**KIRKLEES METROPOLITAN COUNCIL
INVESTMENT & REGENERATION SERVICE**

**DELEGATED DECISION FOR APPLICATION FOR CERTIFICATE OF
LAWFUL DEVELOPMENT**

Reference no.: 2025/CL/92136/E

Description: Certificate of lawfulness for proposed erection of
single storey rear extension

REAR ELEVATION (PROPOSED)

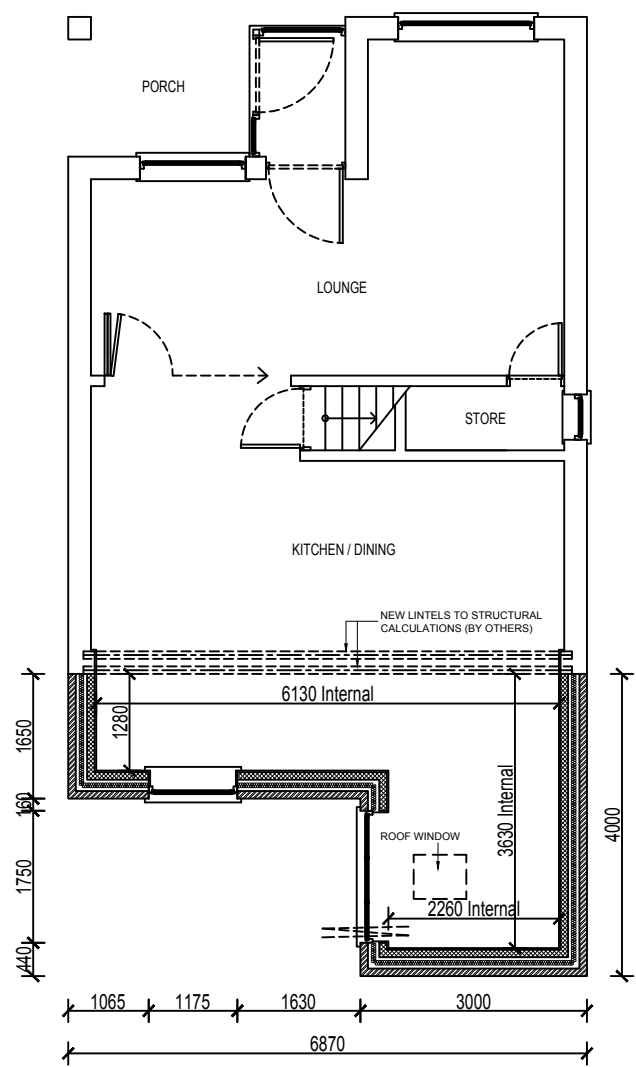
The proposed extension would be 'L' shaped in its design spanning the full width of the rear elevation of the property. The extension would project 1.65 metres on the side elevation facing the vehicular access and 4 metres from the side elevation facing No. 23. The eaves height would be 2.36 metres with an overall height of 3.6 metres.

Comment: *The enlarged part of the dwellinghouse would not extend beyond the rear wall of the dwellinghouse by more than 4 metres and the height would not exceed 4 metres.*

Comment: *The enlarged part of the dwellinghouse would be within 2 metres of the boundary however the height of the eaves would not exceed 3 metres.*

Drawing Number: 07-2025-2002

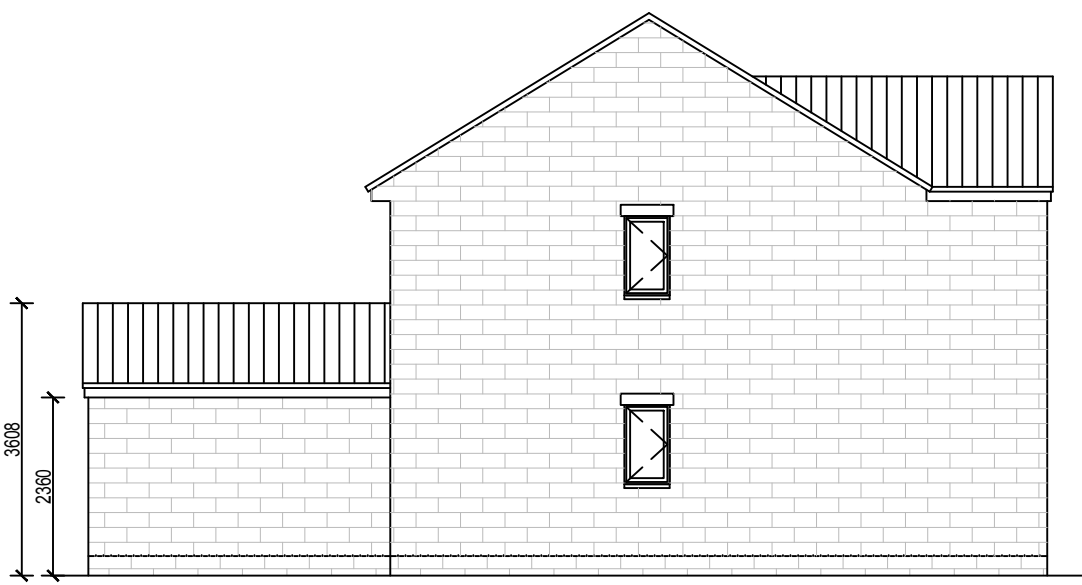
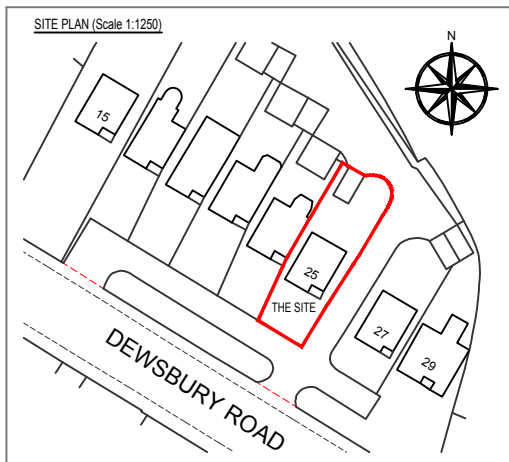
Comment: *Submitted drawing number 07-2025-2002 – 1 of 1 is annotated to demonstrate that the construction materials would match the host dwelling. No upper floor windows are proposed within the side elevation wall or roof slope.*
